Application no: H08-0124-15

Description: Proposed pair of semi-detached houses

Location: Site adj. to 8 Belchmire Lane

ACKNOWLEDGEMENT OF AMENDMENT

Drawing **Planning (Location and Block Plans)**

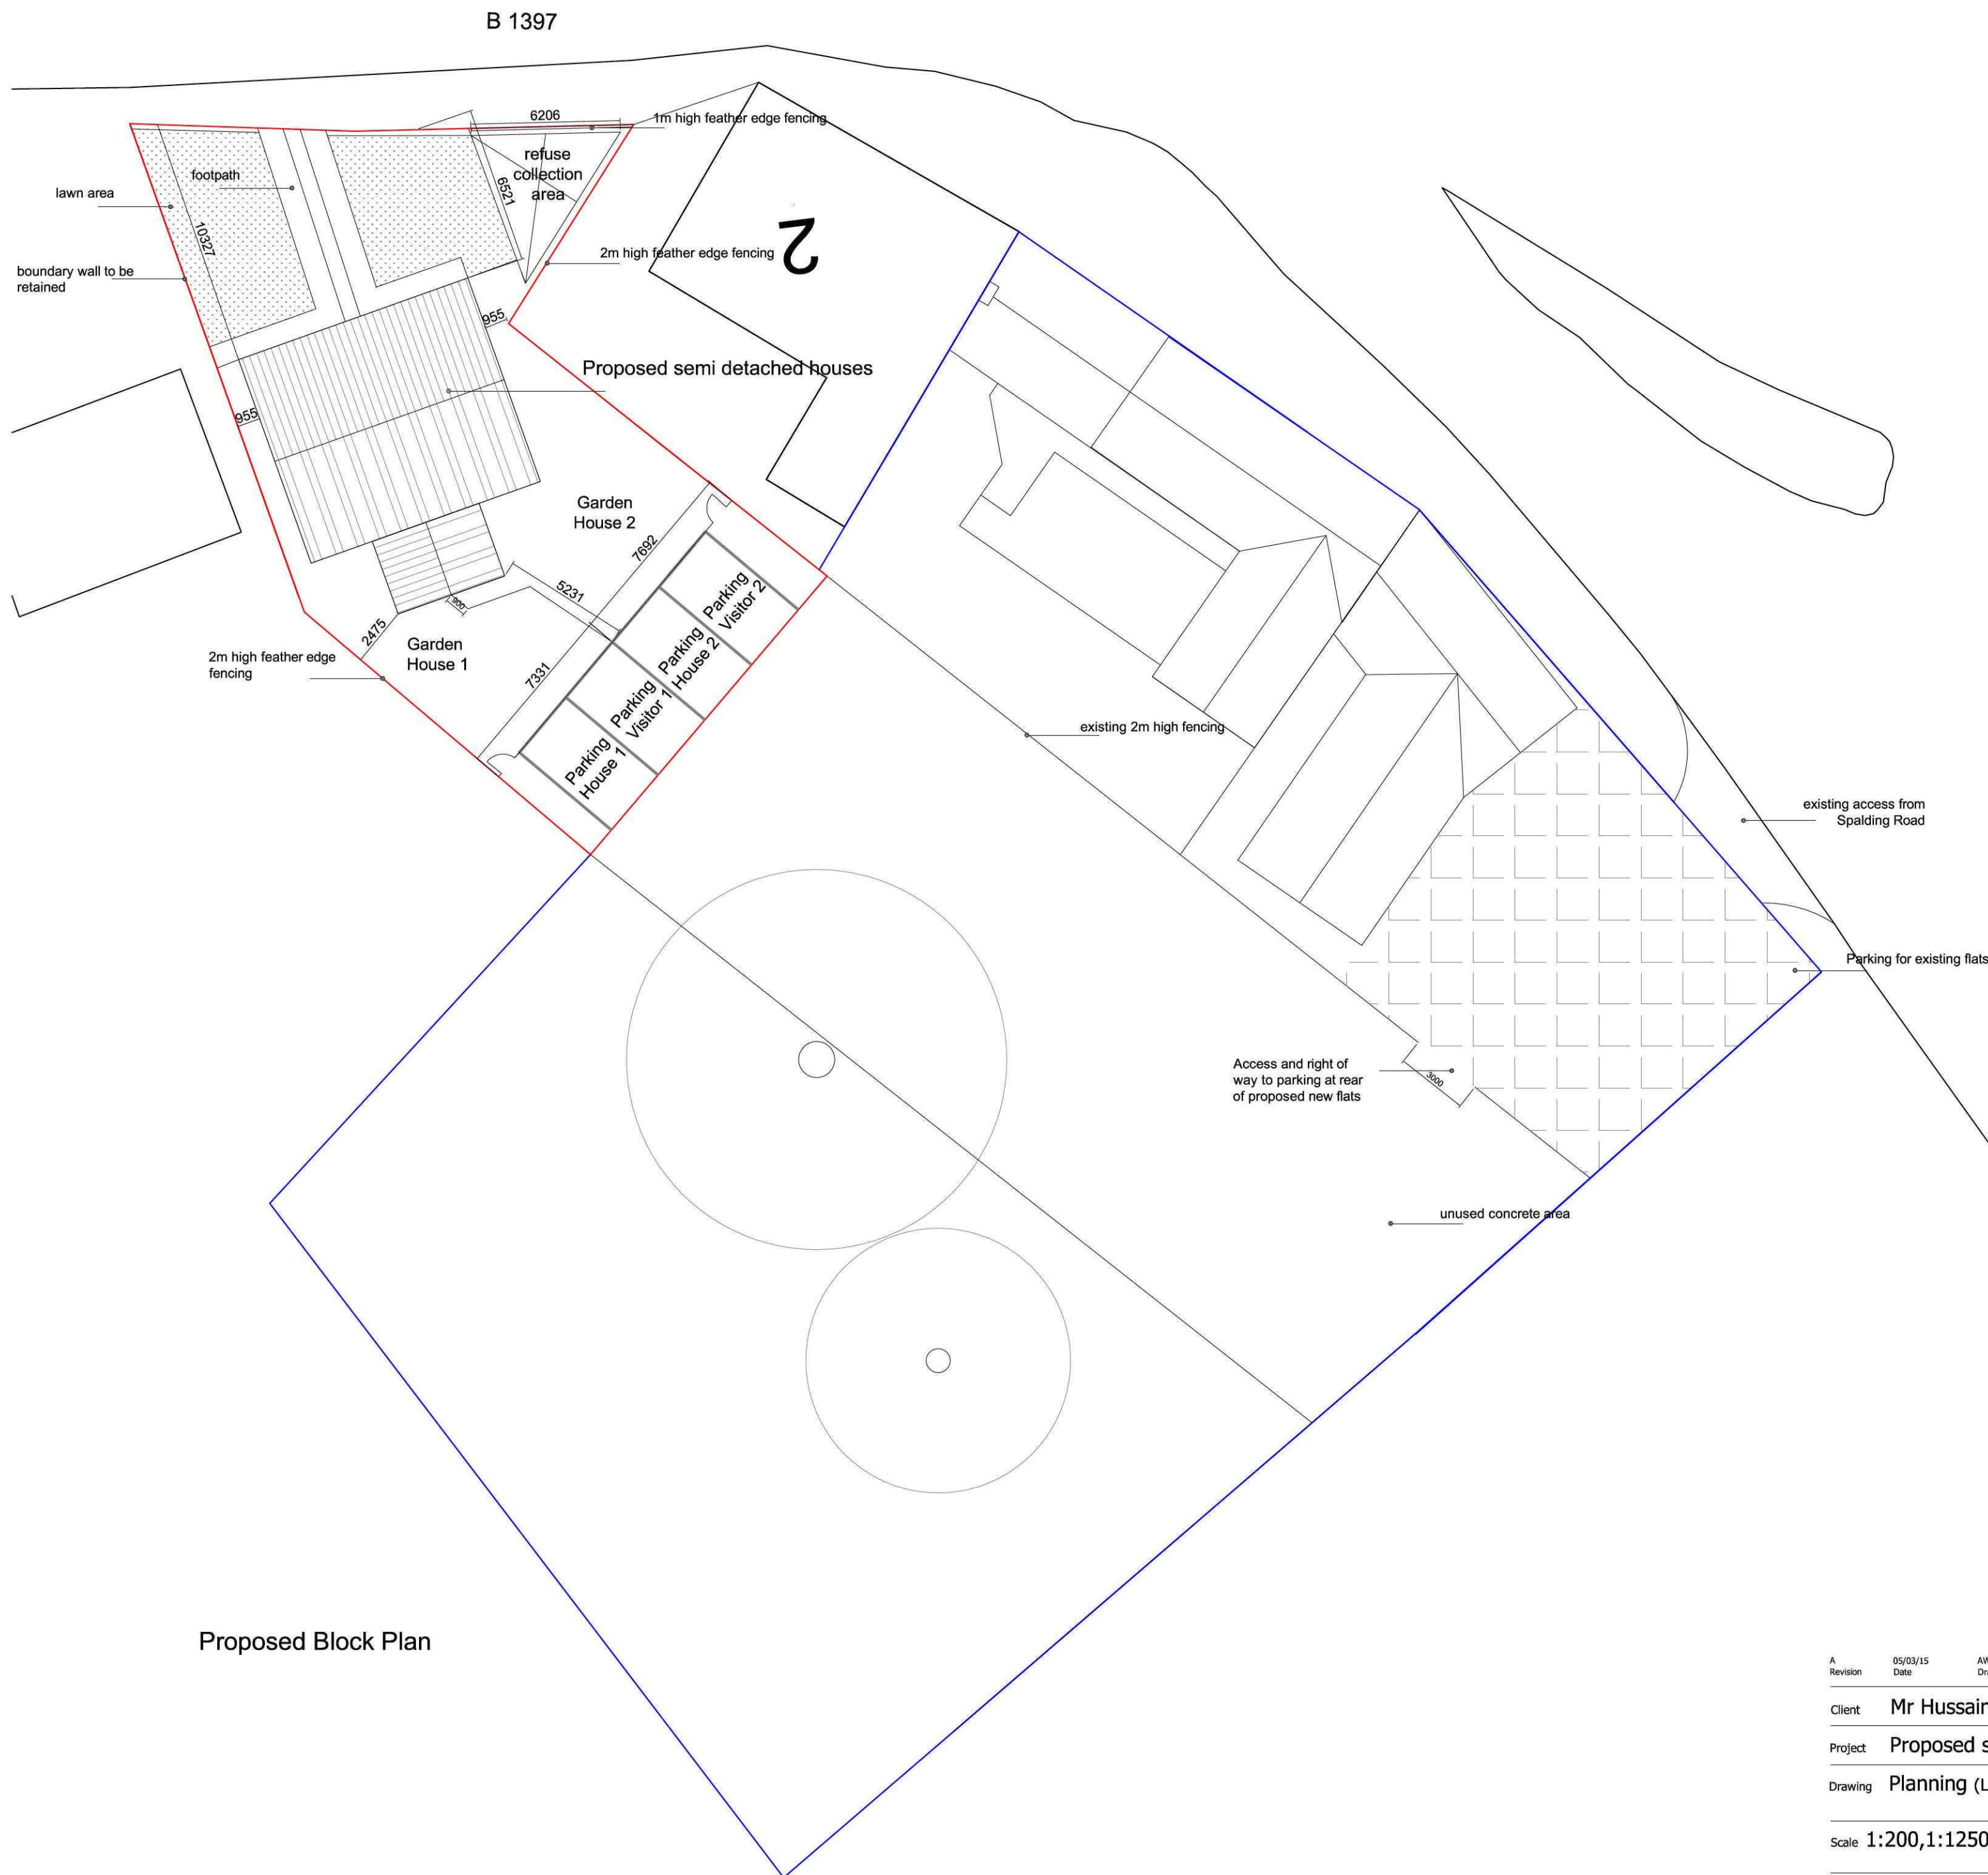
Amendment: Alteration of parking arrangement
(dwg. nos. 14/394/PA/006 and 14/394/PA/007A)

In light of concerns raised by the Highways Authority, please find attached a Planning Amendment form and new drawings altering the parking arrangements.

Further to my telephone conversation with Phil Norman, dealing with the amendment to the above application. Please substitute the previous version of drawing, Planning (Location and Block Plans), drawing number 14/394/PA/007, with the revised drawing attached. The other drawing attached to the amendment, Planning (Elevation and Floor Plans) drawing number 14/394/PA/006 still stands.
